PROPOSED ALDI FOODSTORE
HOSTMOOR AVENUE, MARCH
TN06 – RESPONSE TO PRE-APPLICATION COMMENTS
23RD FEBRUARY 2021

Appendix 2 – Proposed Signal Junction Layout Sketch

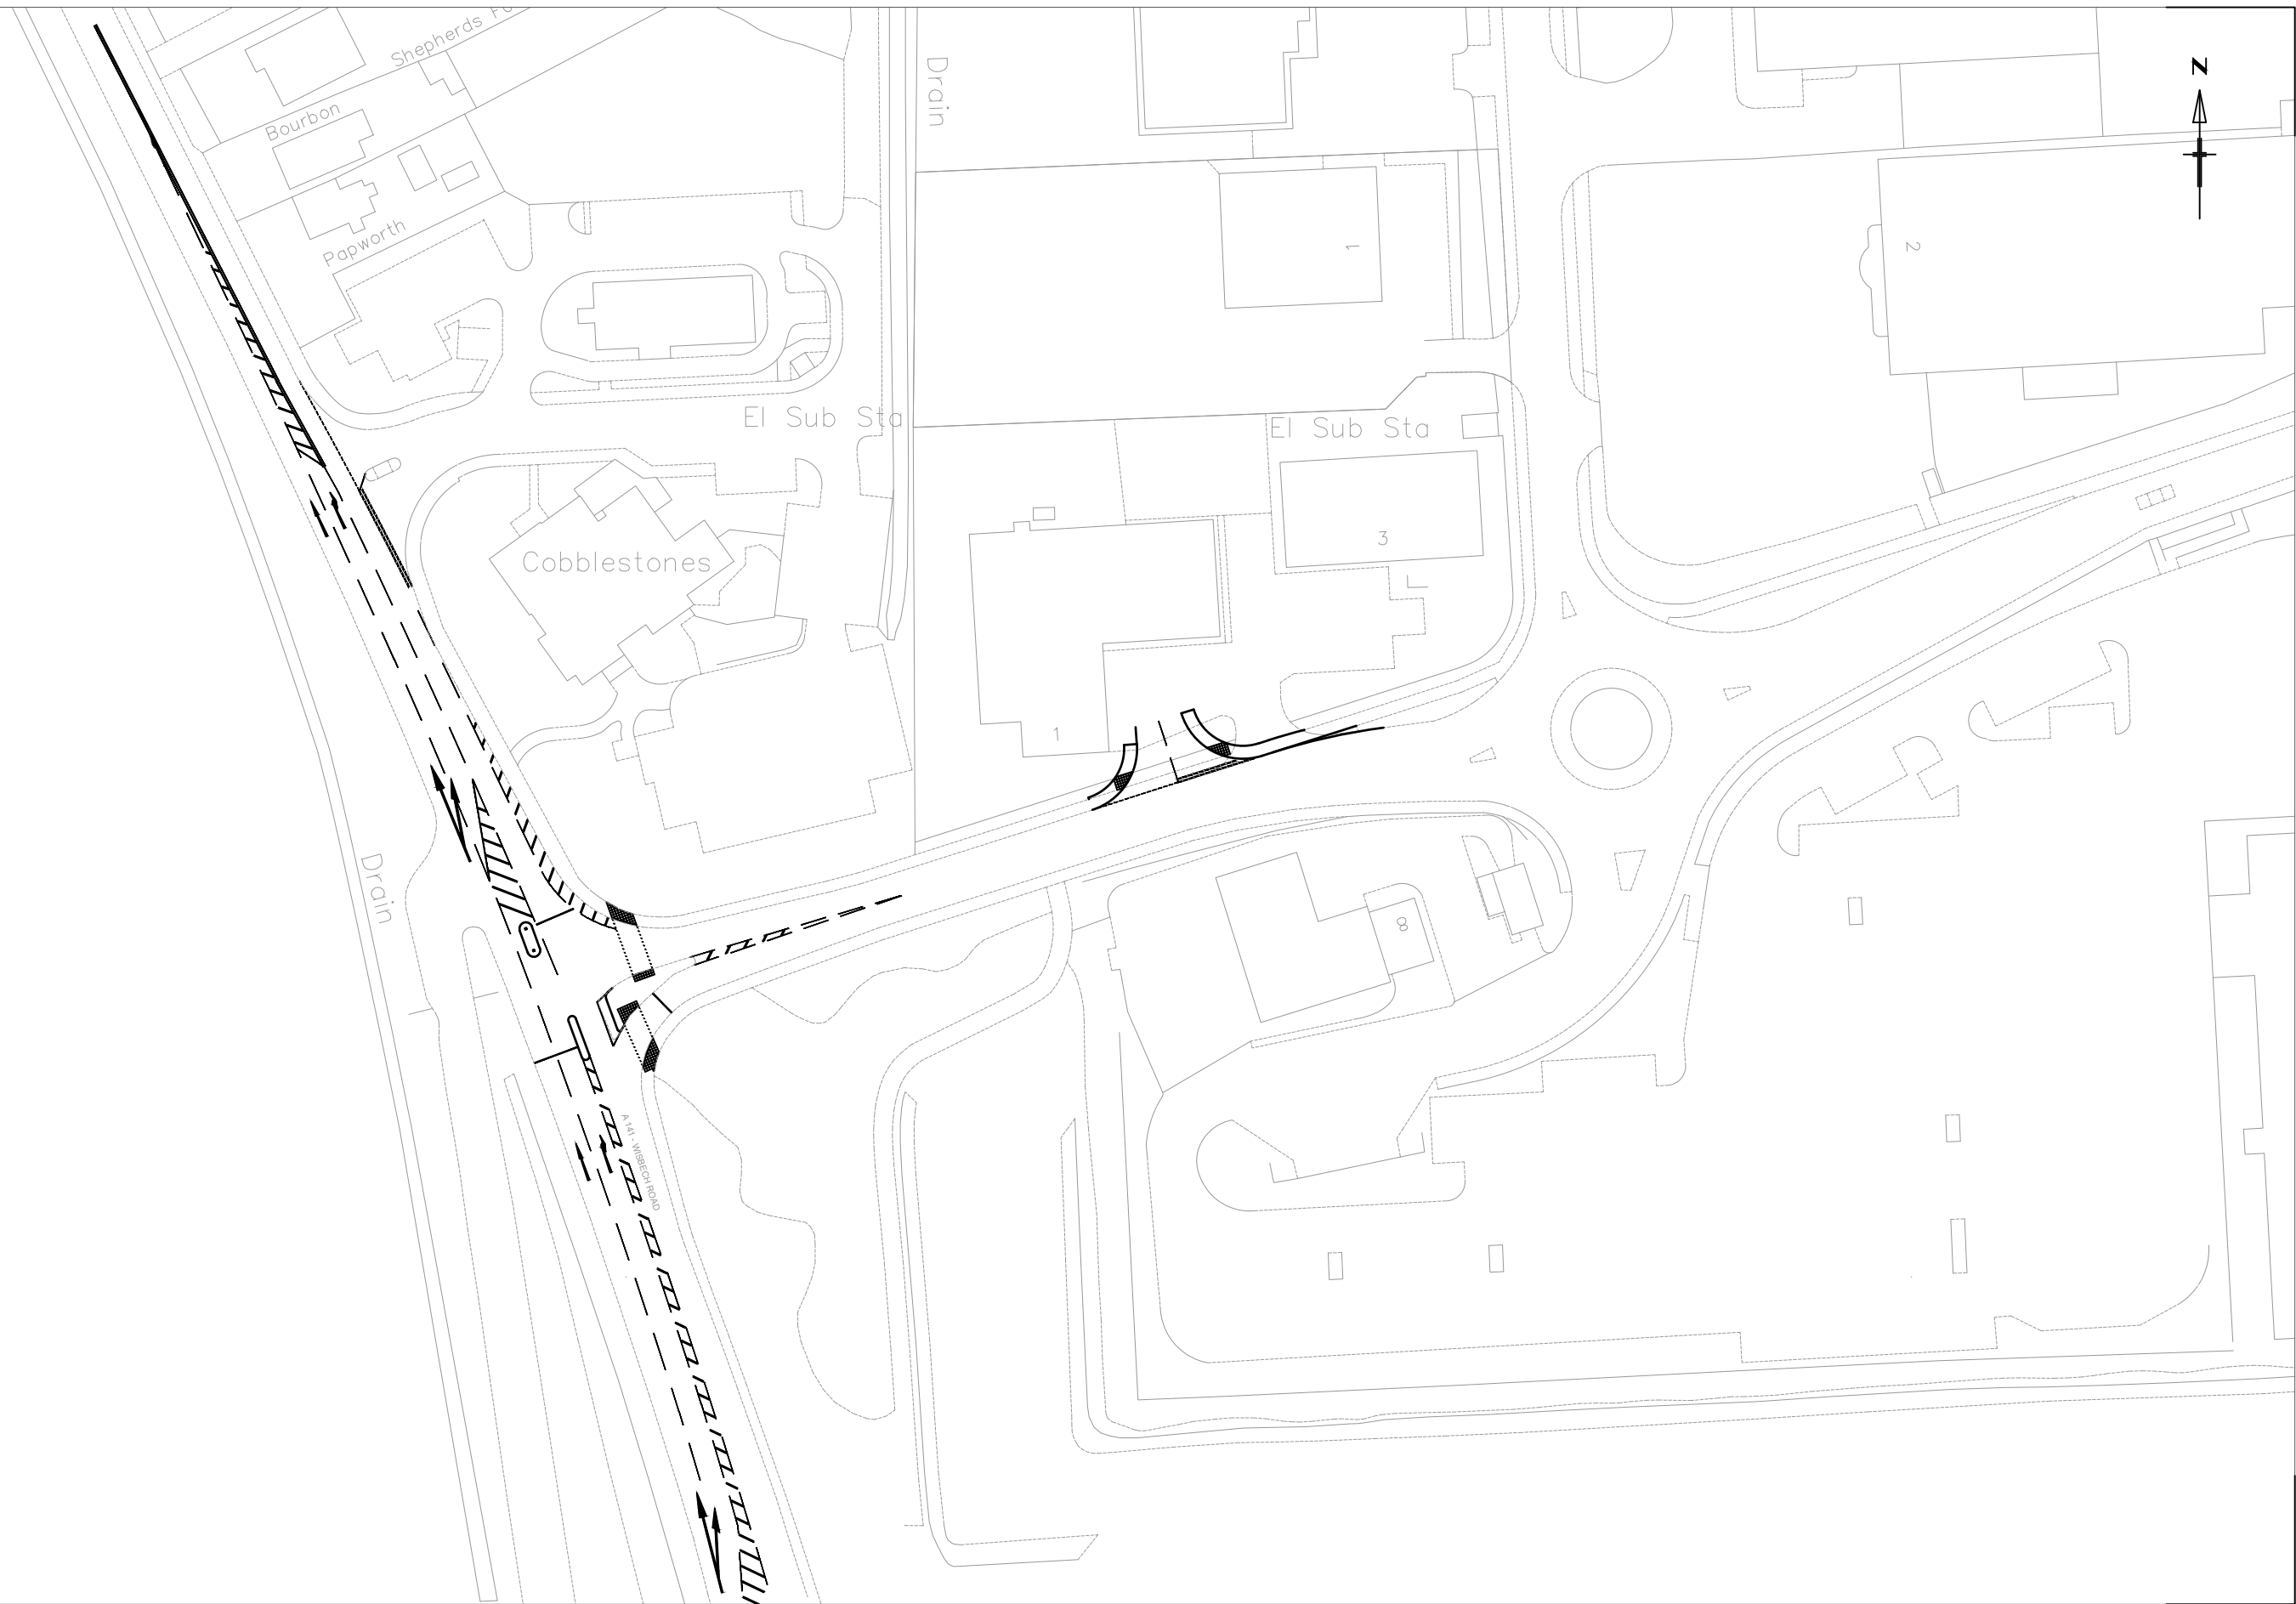
"General proposal layout - Somebody leaving Hostmoor and wanting to head north up the A141 are going to be forced out left. The suggestion is that they will then use the roundabout to U-turn. If this is the chosen option, to prevent drivers from coming out left and then performing a dangerous manoeuvre to turn immediately right after the island and approach the northbound lane to the signals to avoid U-turning at the roundabout, then an island would be required connecting all the way to the roundabout, with a barrier to stop people driving over the central kerb. A Safety Audit is likely required at the planning application stage to assess the safety of this junction design."

"The forced left turn also complicates any future expansion into the land opposite which would require a fourth arm. If a fourth arm was added to the junction in the future, the junction would likely be heavily over capacity. It would be better to access development on the land opposite from another location."

"At a basic level it looks like the right turn has been taken away from Hostmoor Avenue because if left in the design then the signals would need another stage, leading to the junction being over capacity."

"The lane width information inputted into the lane saturation flows looks wrong. On the southbound arm they have declared a 5m lane. It might be 5m at the stop line but as you get back up the link it narrows, in practice greatly reducing the saturation flow of the important link. Comparing this with other links I'd suggest the sat flow would go down from the 2082 to about 1990 vehicles per hour."

2.8 The existing restriction of left-turns only from Hostmoor Avenue to the A141 will be retained for the proposed signal layout. The curved nature of the approach lane, as well as the existing signage making clear that right turns are prohibited, ensures that illegal right-turn manoeuvres will unlikely be a regular occurrence.

2.9 Therefore, Connect deem it unnecessary constructing a barrier on the carriageway to physically prohibit U-turns because there have been no existing tendencies reported for this movement to justify such an action.

2.11 The proposed signal scheme is designed with the intended exclusion of the Westry Retail Park development, which will be served by a future roundabout.

2.13 There is no permitted right-turn in the existing layout so it has not been taken away but rather retained as existing.

2.30 The revised signal junction layout includes separate left-turn and ahead lanes for the A141 southbound approach which results in adjustments to the saturation flows.
